From: Ewan Stewart <Ewan.Stewart@Cherwell-DC.gov.uk>
Sent: 24 February 2022 14:45
To: Nathanael Stock <Nathanael.Stock@Cherwell-DC.gov.uk>
Cc: Frances Evans <Frances.Evans@cherwell-dc.gov.uk>
Subject: 21/02893/REM Hook Norton Rd Sibford Ferris - revised plans

My initial thoughts are that the applicant has not addressed previous comments regarding the layout and although there is some improvement with the 2 maisonettes now being at the edge rather than above garages, the elevations for plots 1 & 2 show that there will be a building (ie covered garage) directly in front of the affordable dwellings.

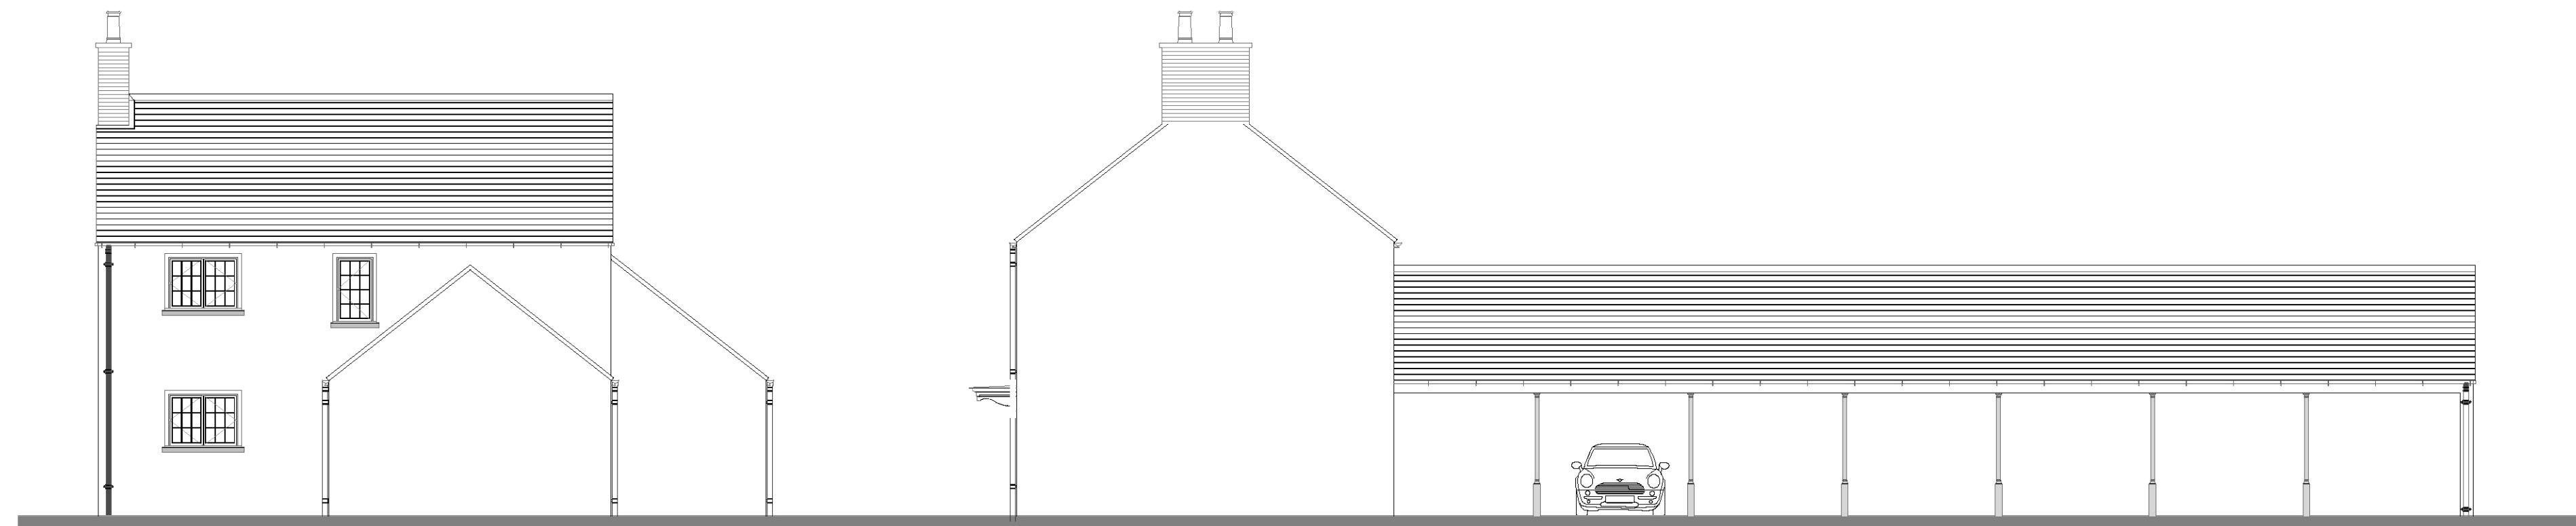
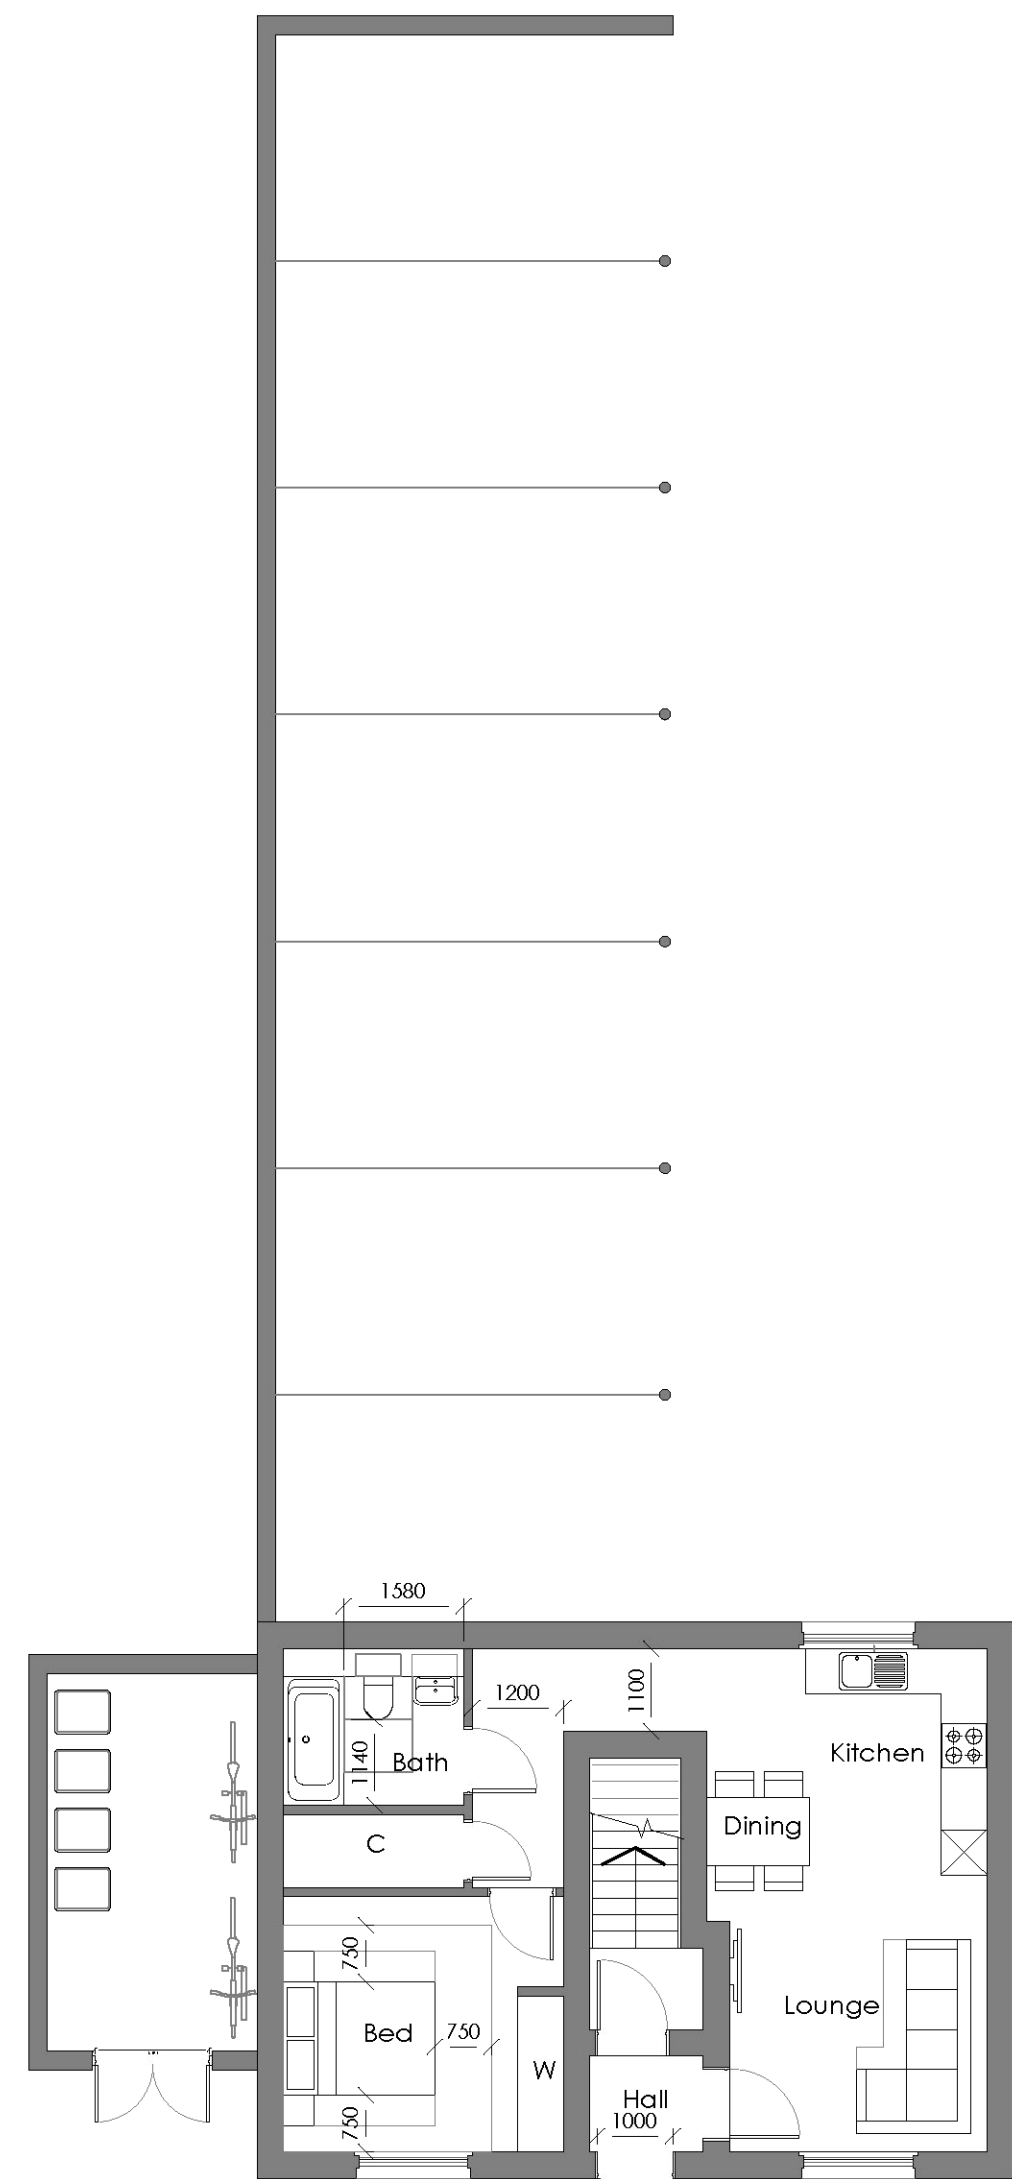
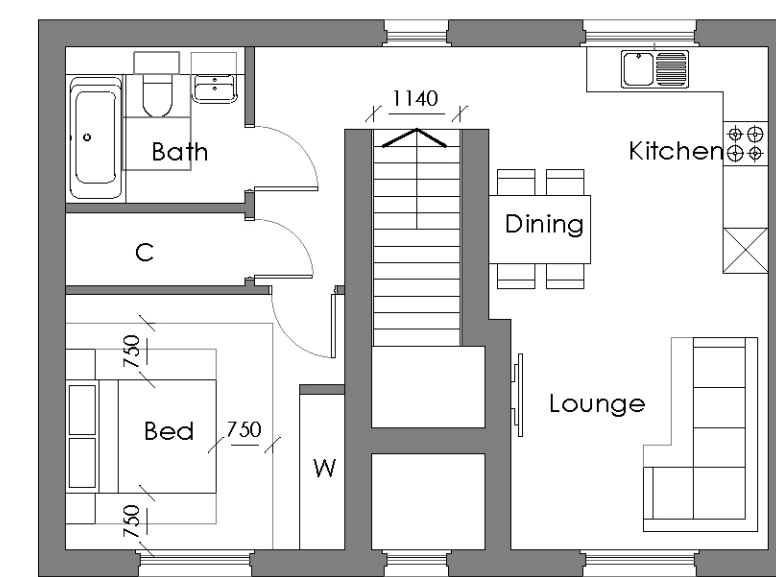
Whilst the height of this has been lowered, it still makes the affordable dwellings stand out because none of the other dwellings have anything like this in front of them. I also can't determine from the plans how the parking requirements of 2 spaces per dwelling for plots 3-9 are going to work.
